POST EPC MEMORANDUM

RE: PR- PR-2018-001482, SI-2023-01925–Site Plan-EPC _ Riverside Mobile Home Park

The agent (Tierra West) for Riverside West, LLC., has worked with Staff to fulfill post EPC requirements to meet Conditions of Approval, 1-11 for the Riverside Mobile Home Park, Site Plan-EPC, zoned R-MC; located at 211 Ervien Ln SW, northwest of the intersection of Ervien Ln and Coors Blvd. See EPC Notice of Decision (NOD) dated January 18, 2024.

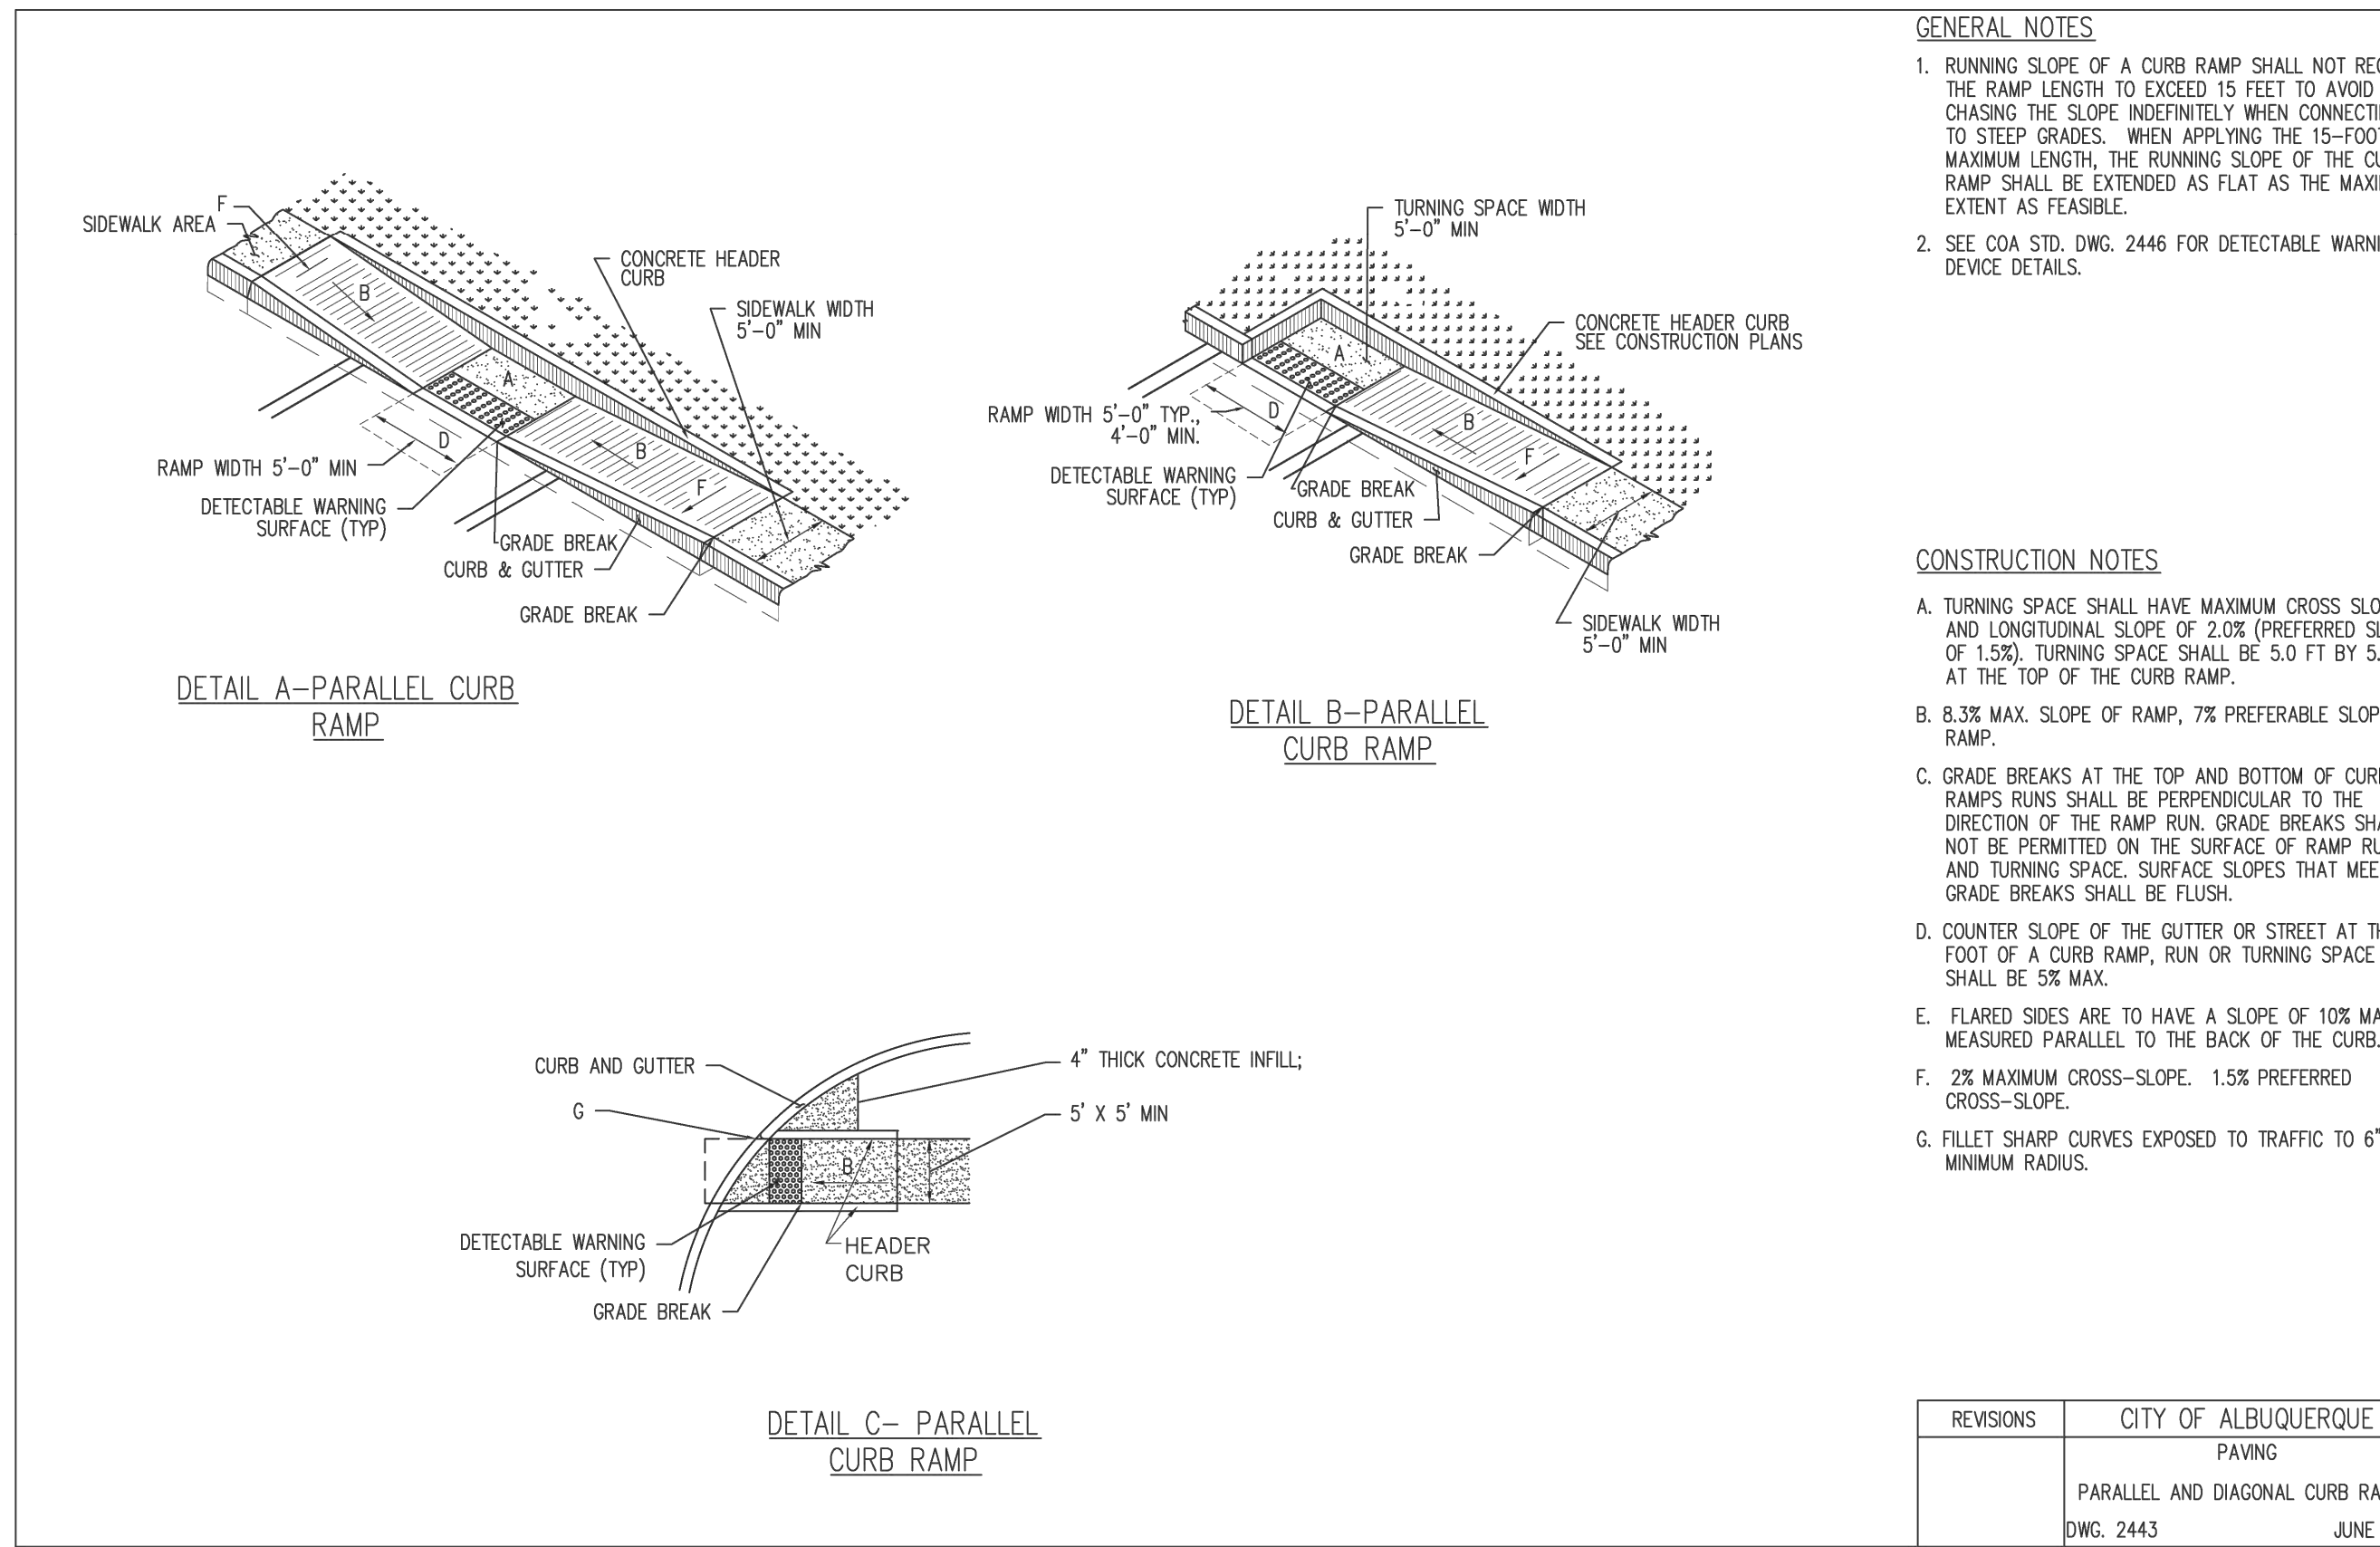
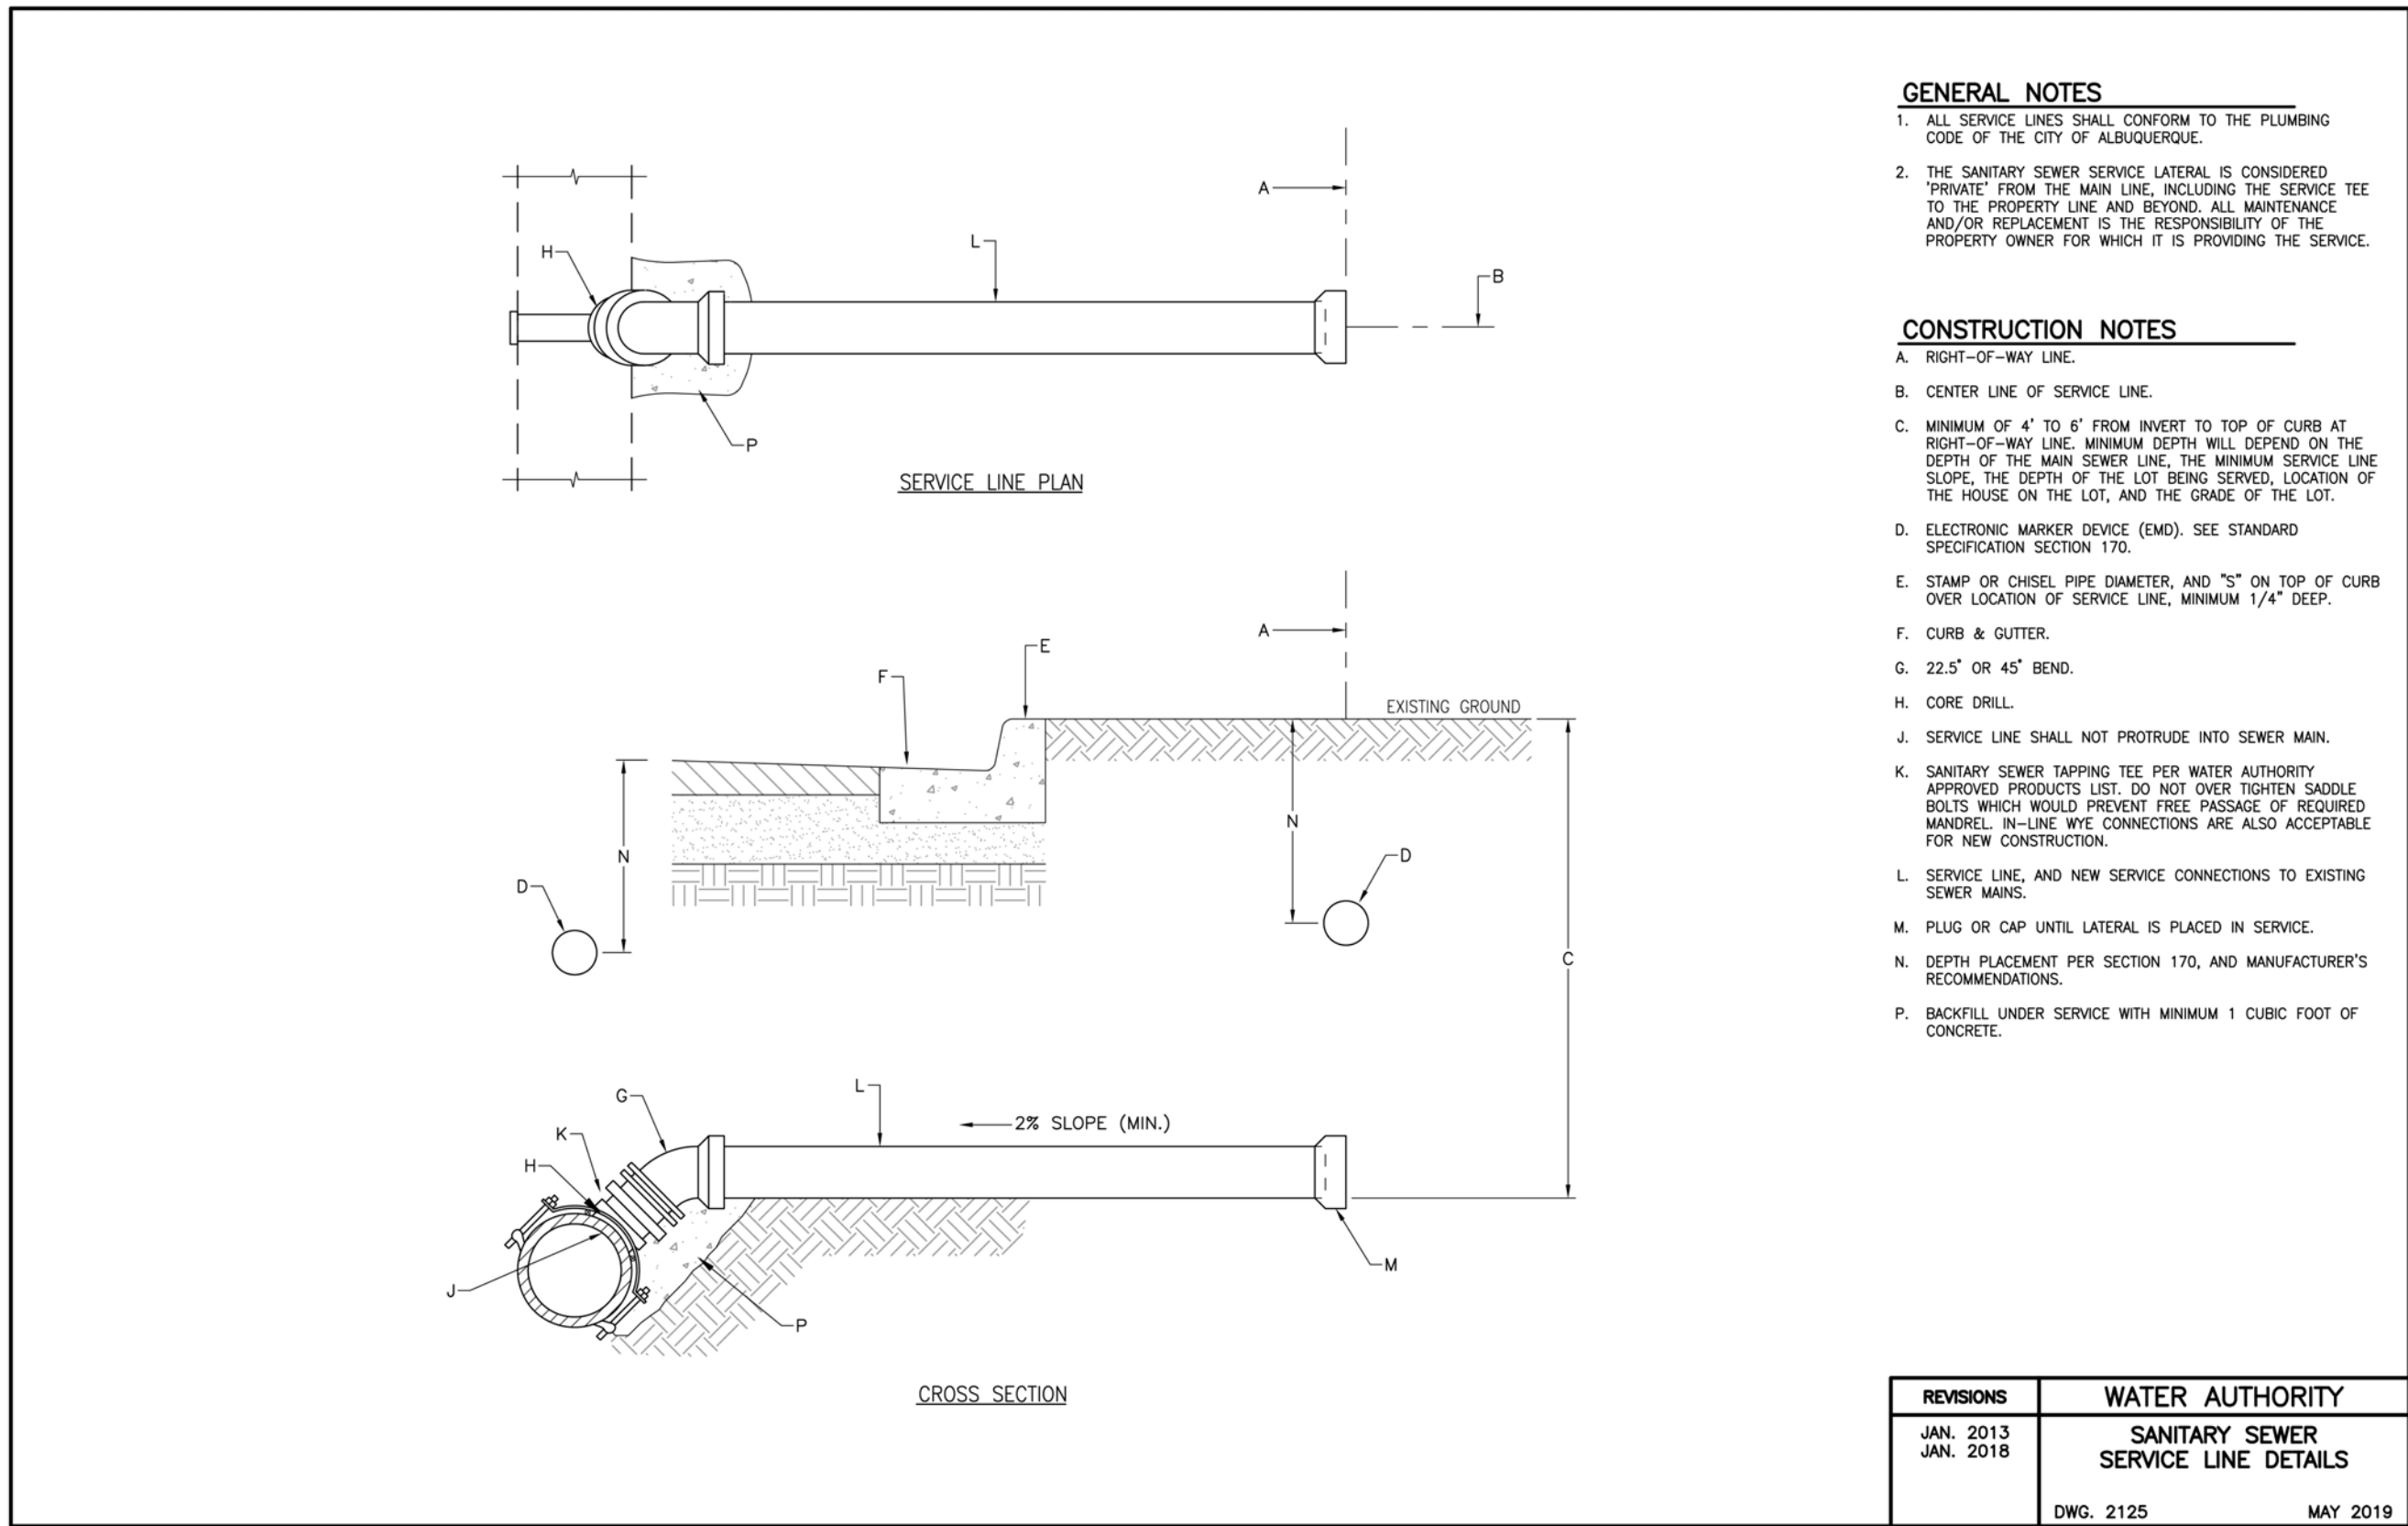
3. Condition 3a has been partially satisfied. Note number 3 has not been changed to reflect the light pole maximum of 16' as shown on Detail Sheet C5.0. Keyed Note number 7 has been changed to reflect this condition.

5. Condition 5 has been met. Conceptual Grading and Drainage Plan has updated text to use "City of Albuquerque" instead of Rio Rancho.
6. Condition 6 has been partially met and replaced with a standard 16' max light pole detail on sheet C5.0. The note, "within 100' of Residential" was not added to the max light pole detail.
